Project Title: Chick-fil-A at Gibson Building Permit #: _____ City Drainage #: _____

Re: **Chick-fil-A**
1600 Gibson Blvd. SE
Grading and Drainage Plan
Engineers Stamp Date 12/15/14 (M12-D015C)

Merrick & Company has reviewed the comments received on February 26, 2015 regarding the proposed Chick-fil-A located at 1600 Gibson Blvd. SE. The following summarizes Merrick's response to the comments provided by the City of Albuquerque.

SHEET TITLE
GRADING PLAN

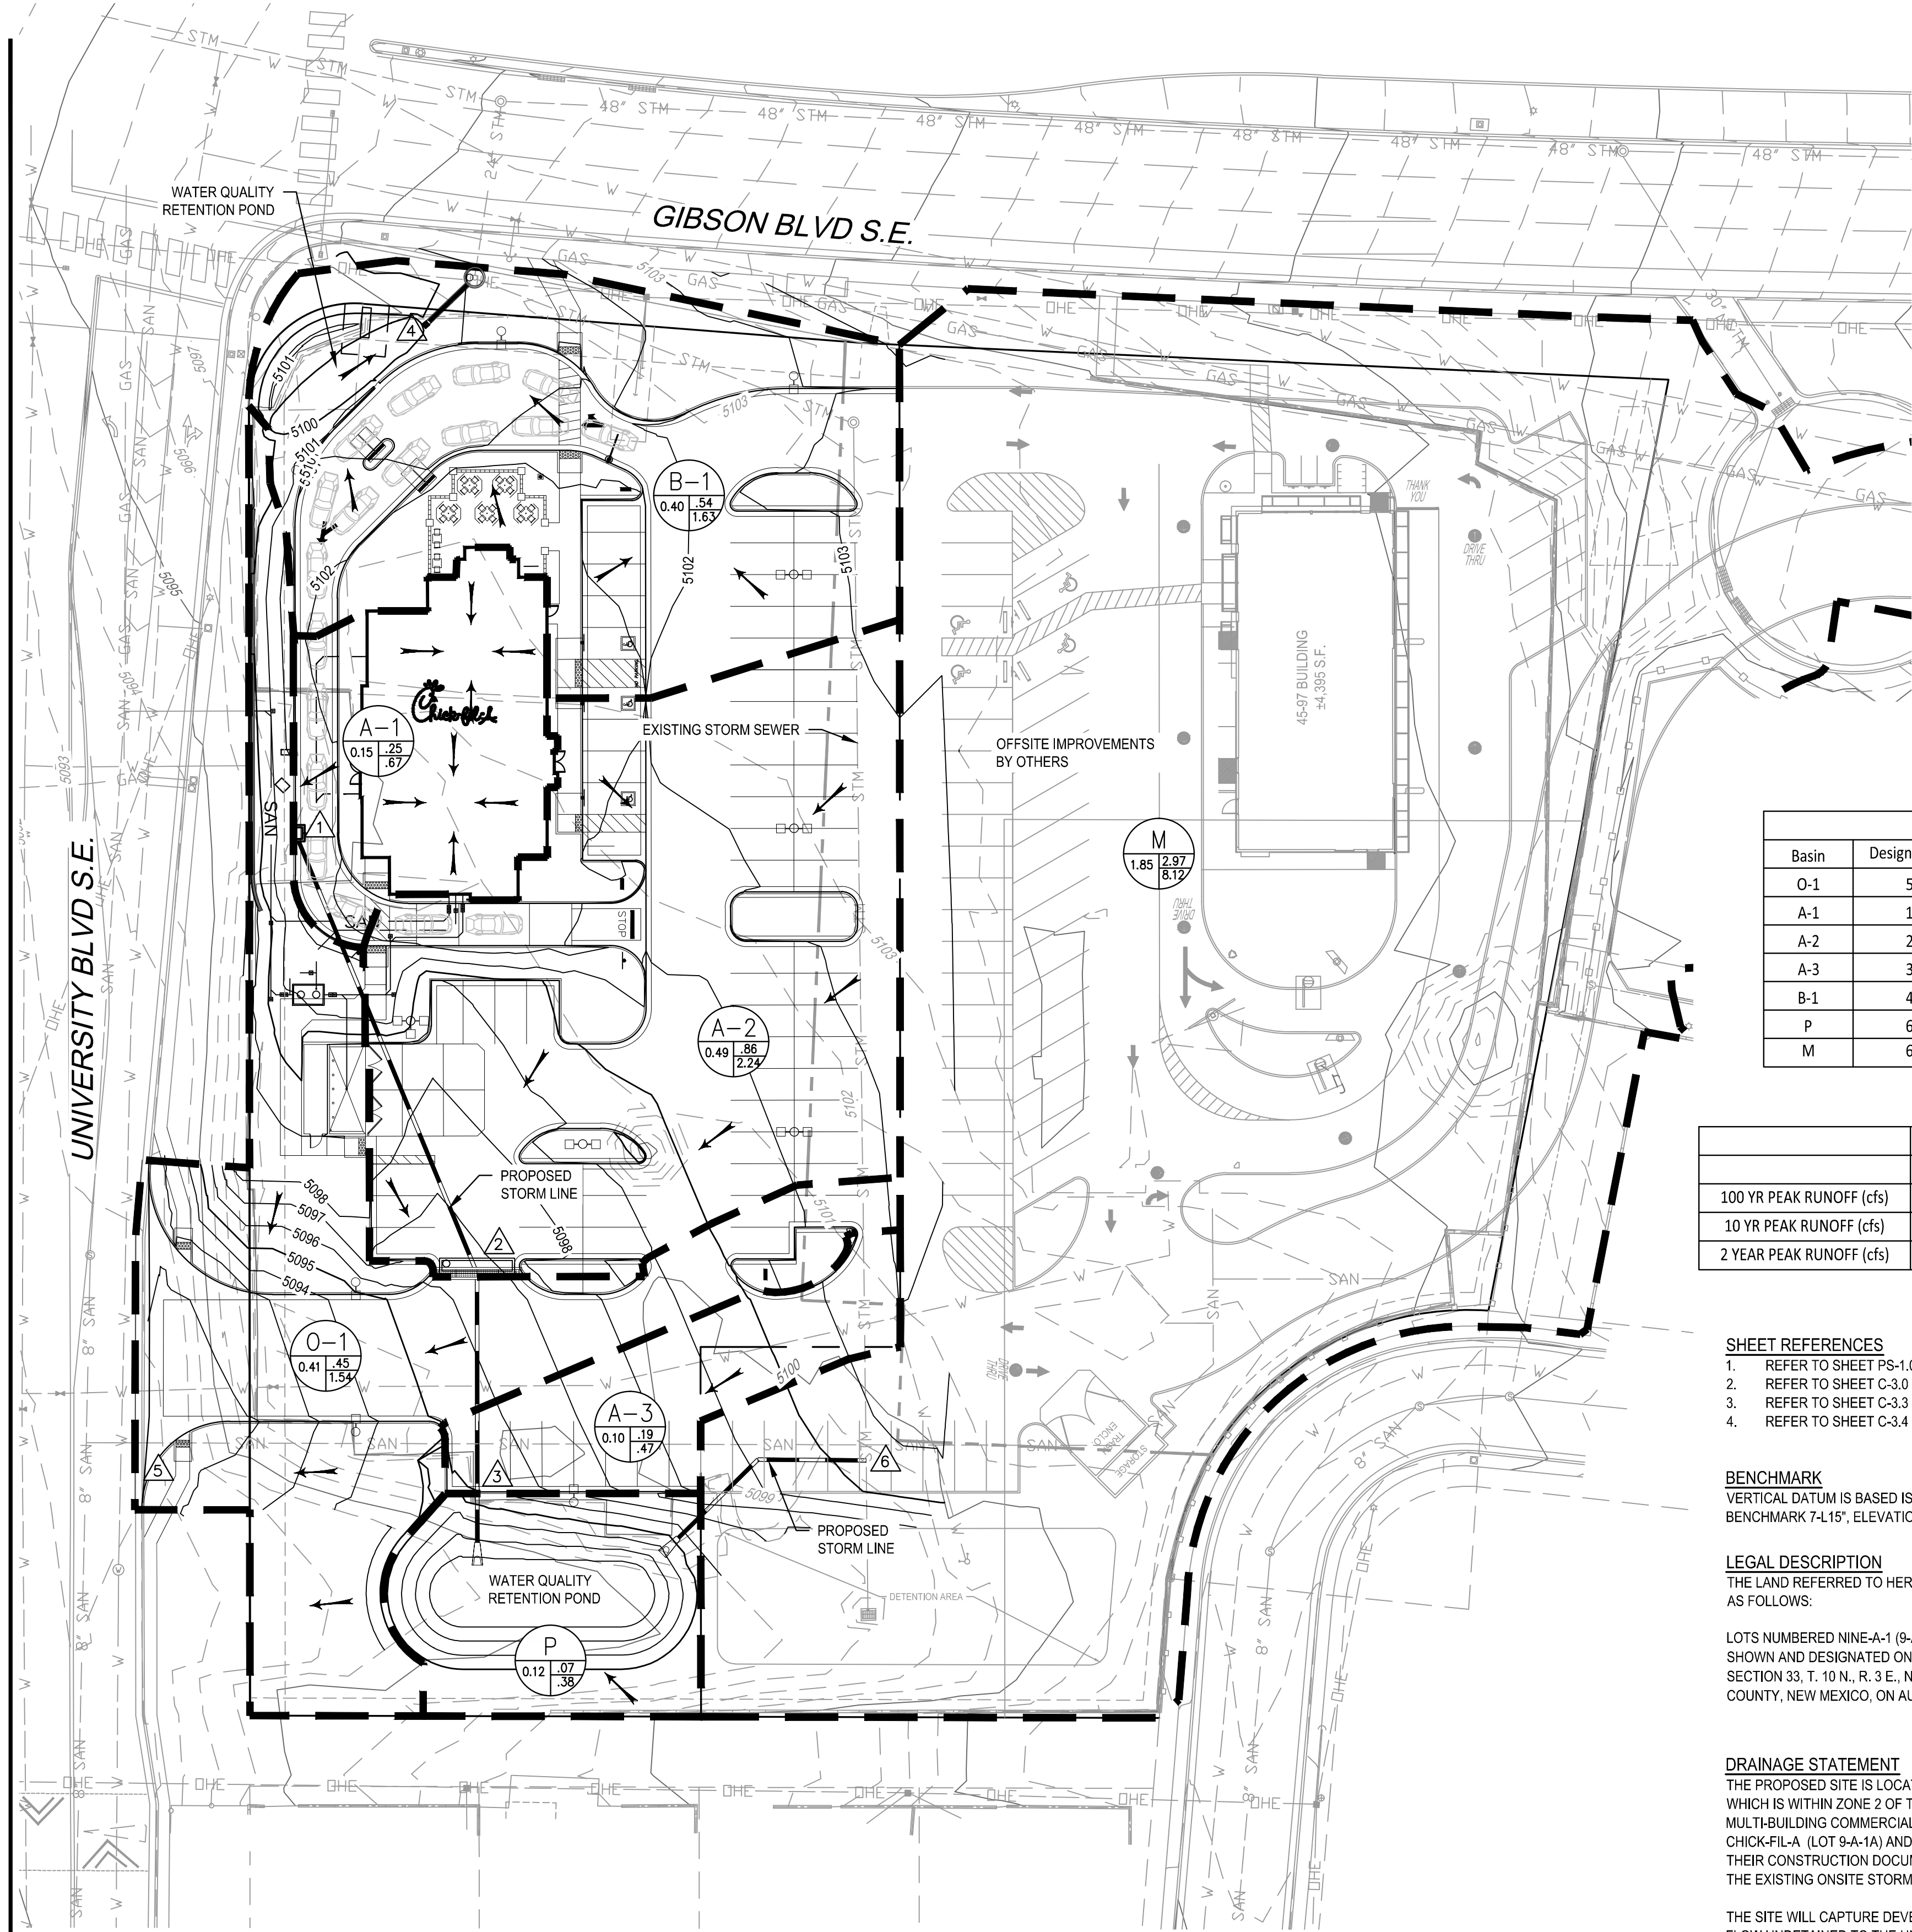
- Provide the legal description on the G&D plan along with the benchmark location.

- There appears to be a ponding area in the drive up lane.

Response: The legal description has been provided of the G&D plan along with the benchmark.

Response: The grading has been adjusted to remove ponding area.

C-3.2

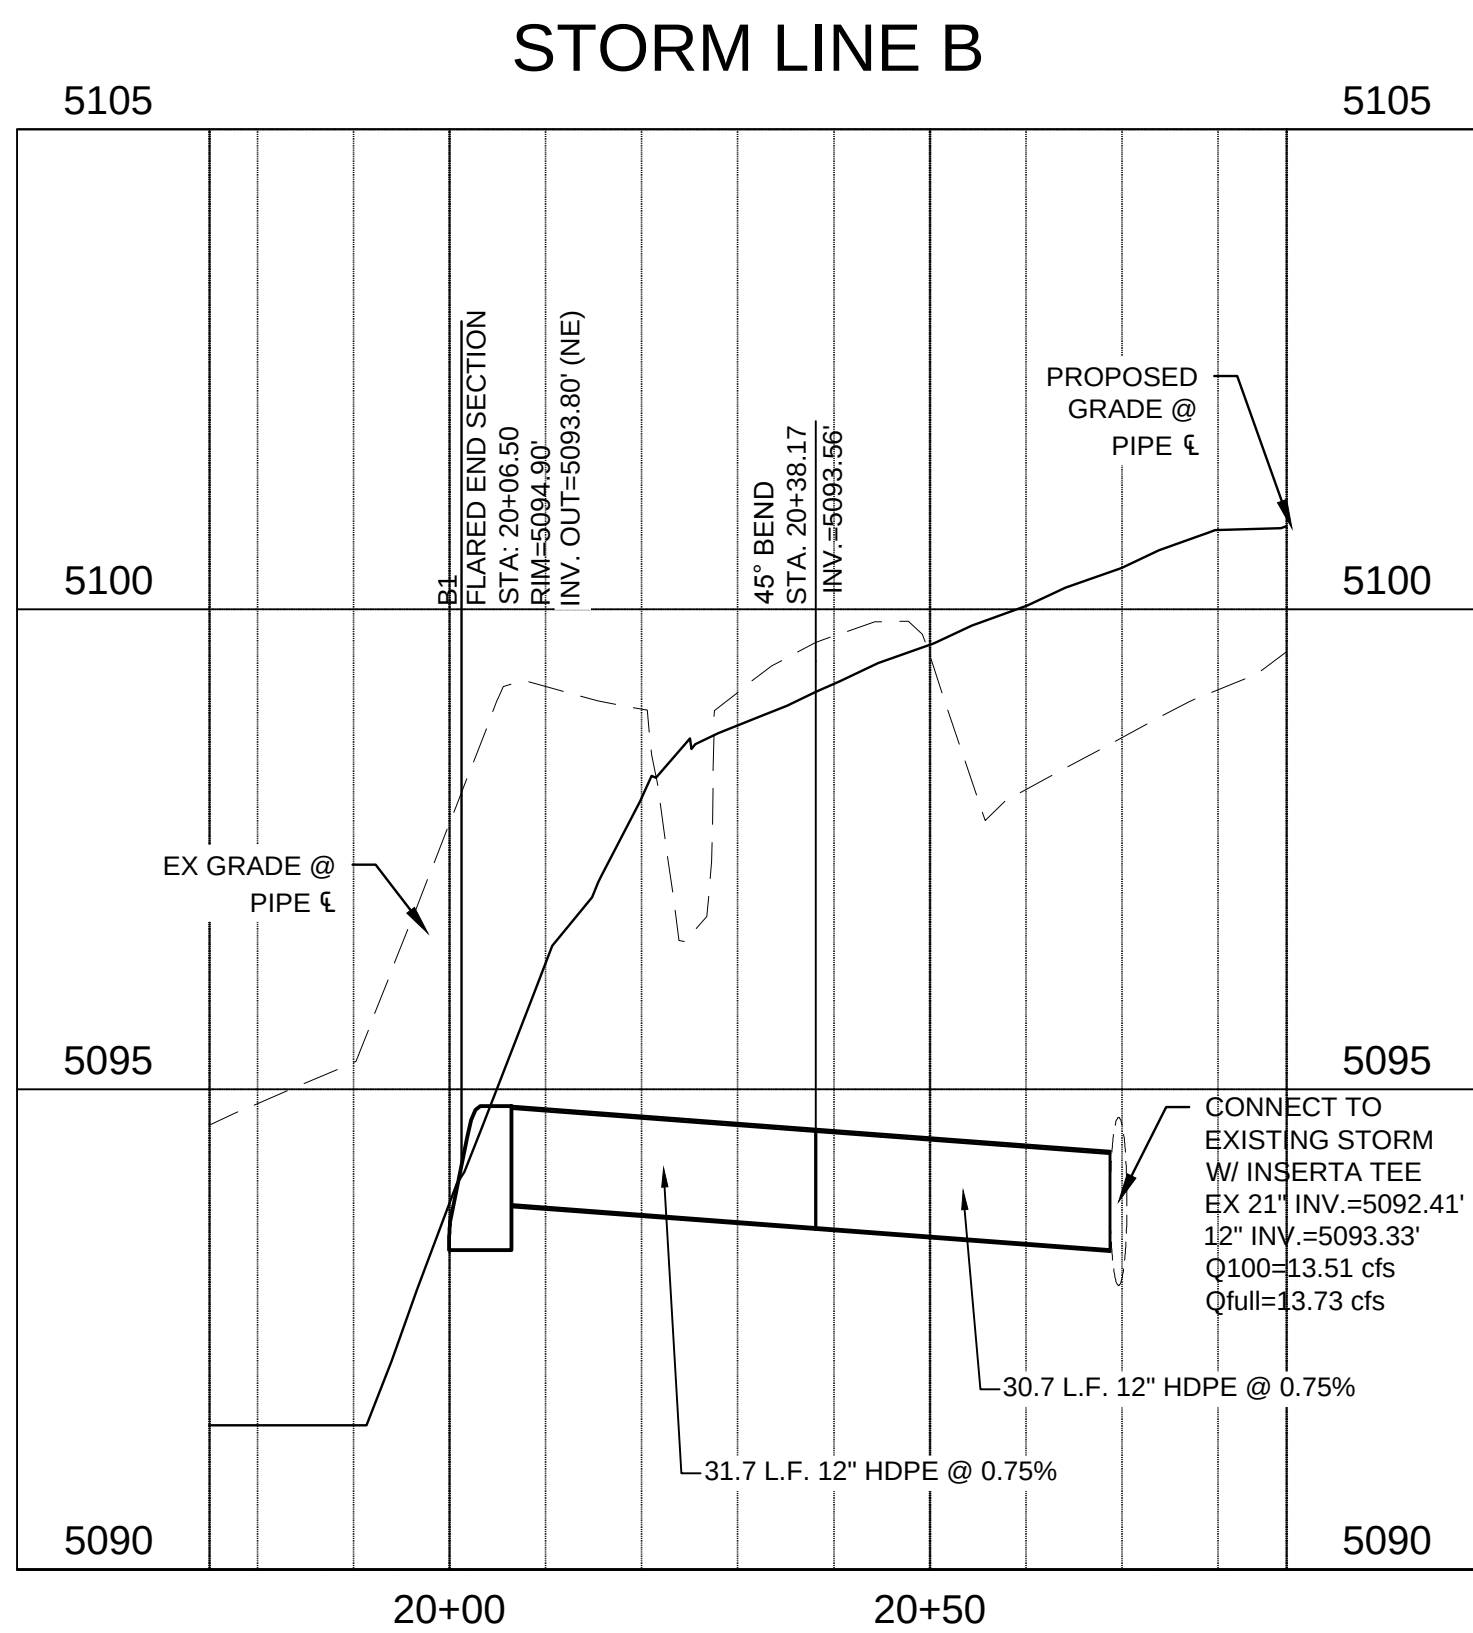
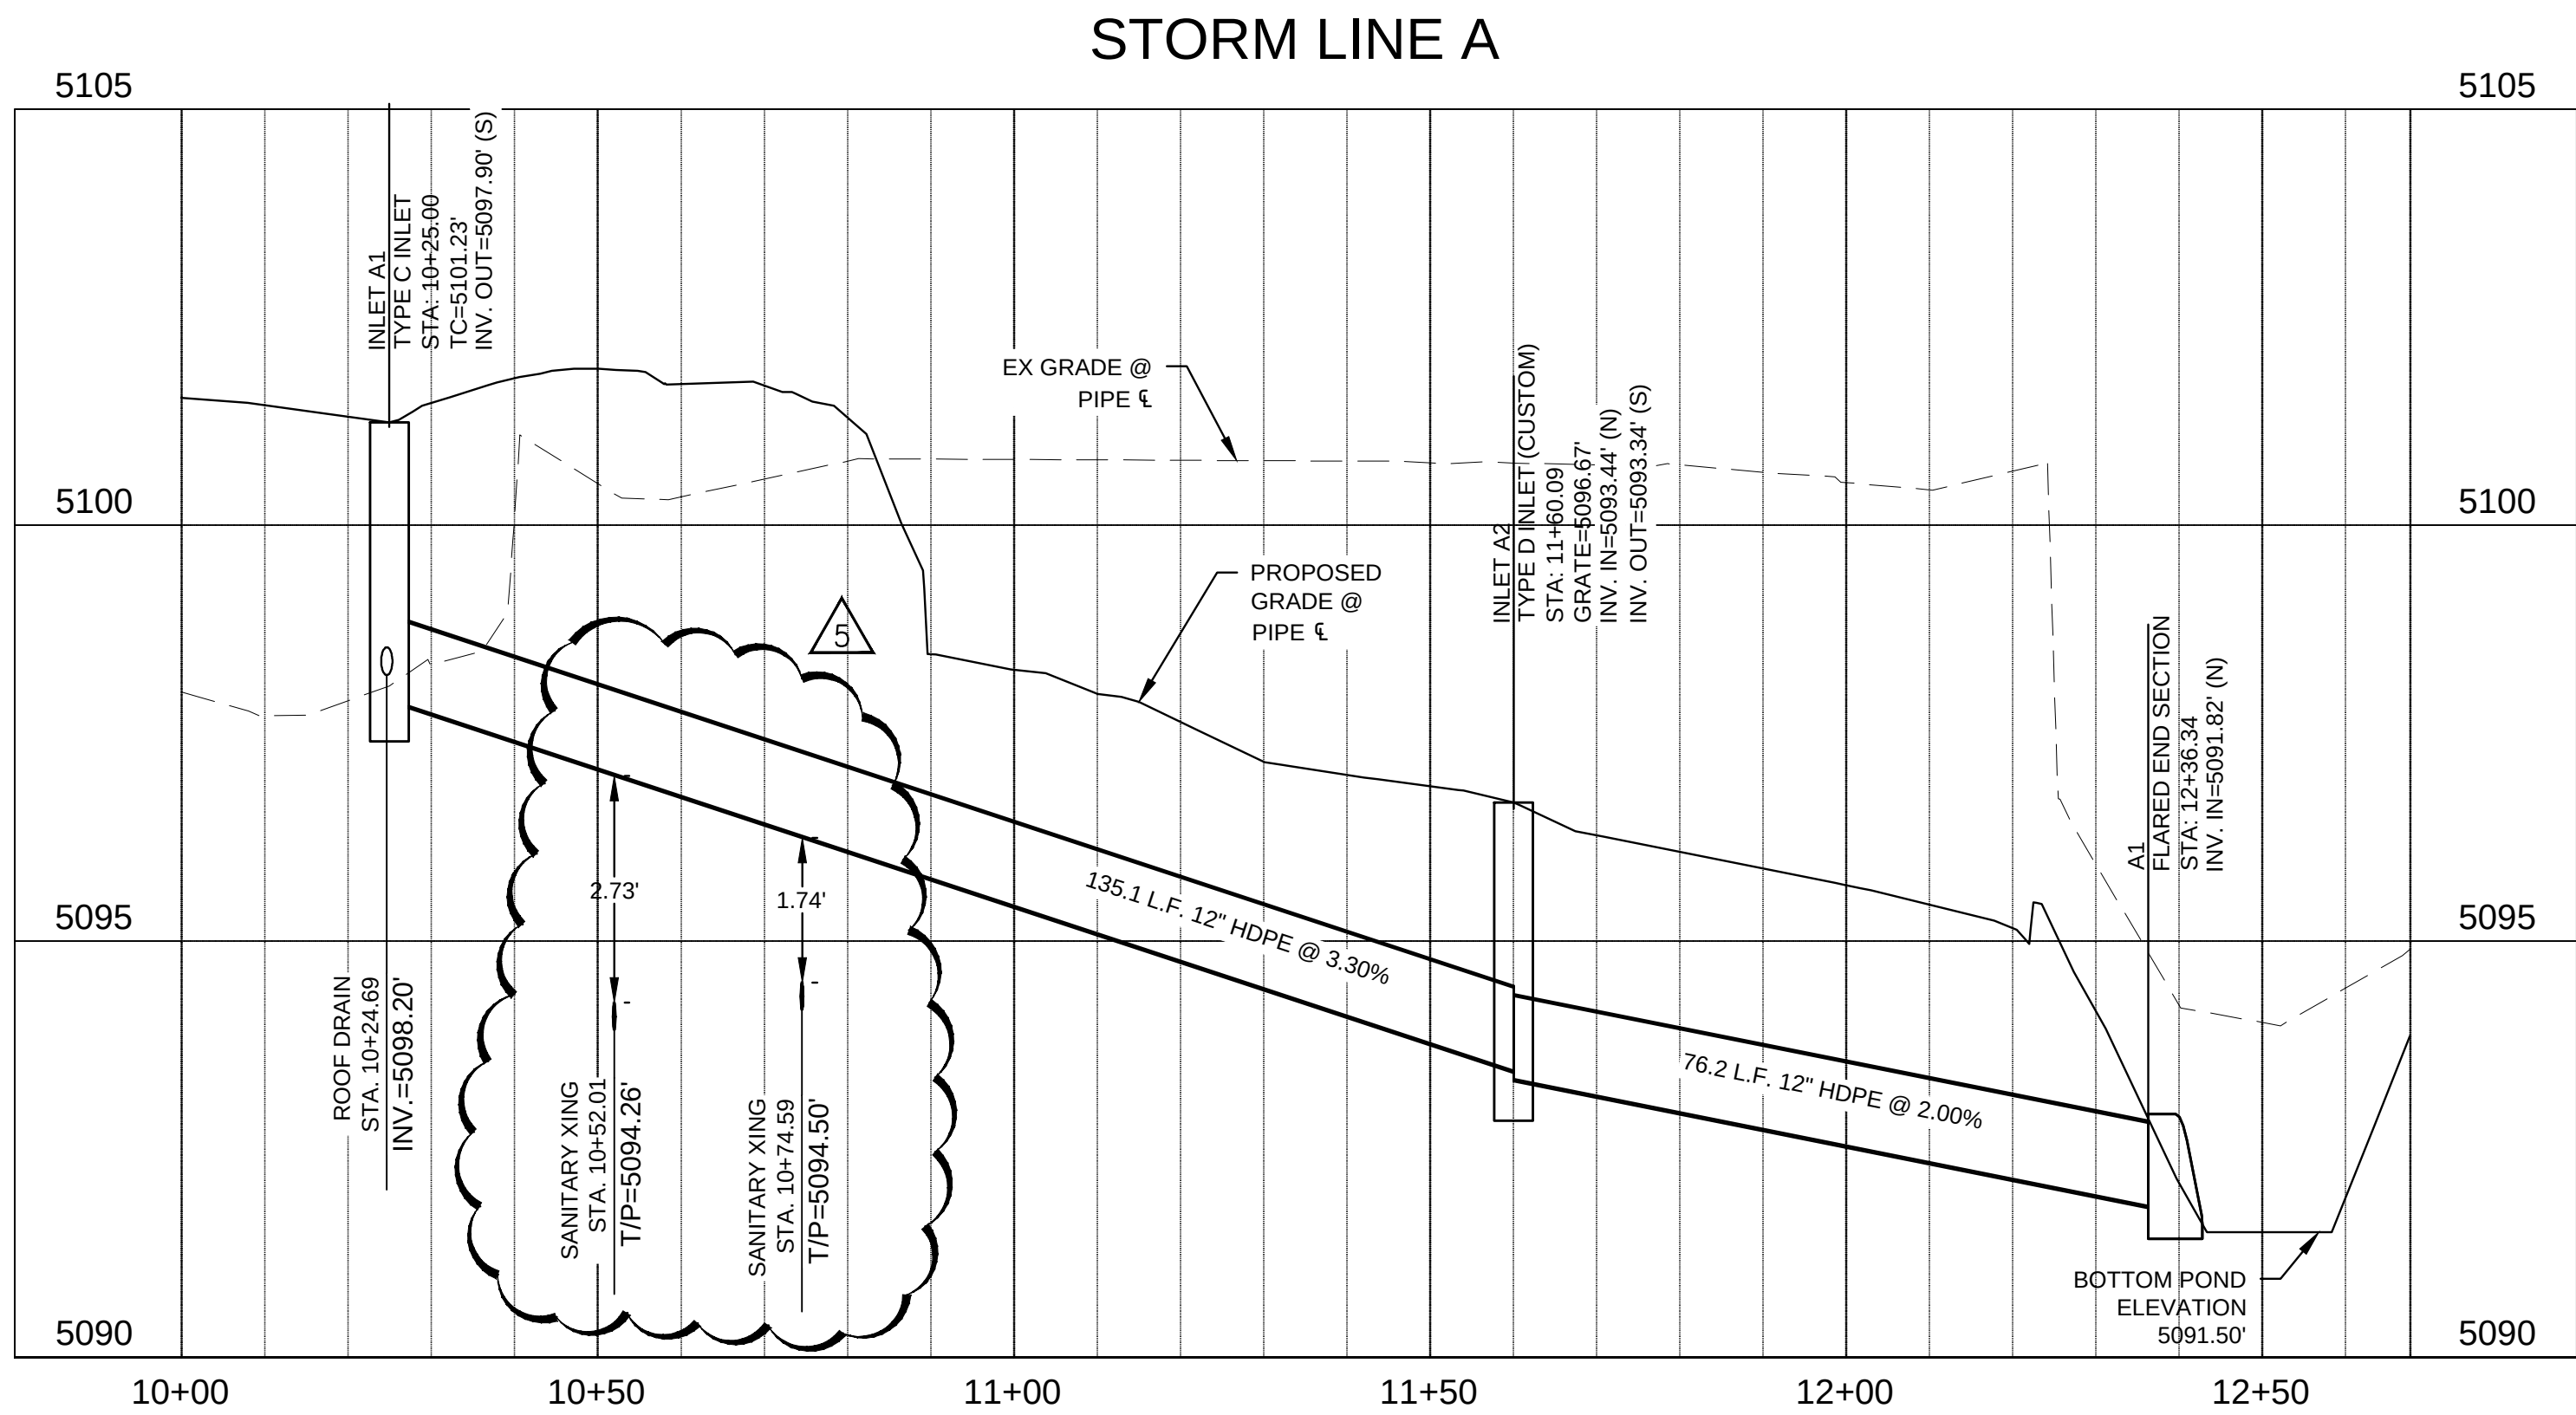
- Mention of the first flush per EPA standards is required. The amount required is .34" times the impervious area. We believe there is enough landscape area to accomplish this requirement.

- Show the roof flows.

- Basin B-1 needs to flow through a first flush retention pond before leaving the site.

Response: The first flush has been mentioned in the drainage statement located on sheet C-3.2.

Response: Roof flows have been added to the drainage map.

Response: A retention pond has been added to retain the first flush from basin B-1
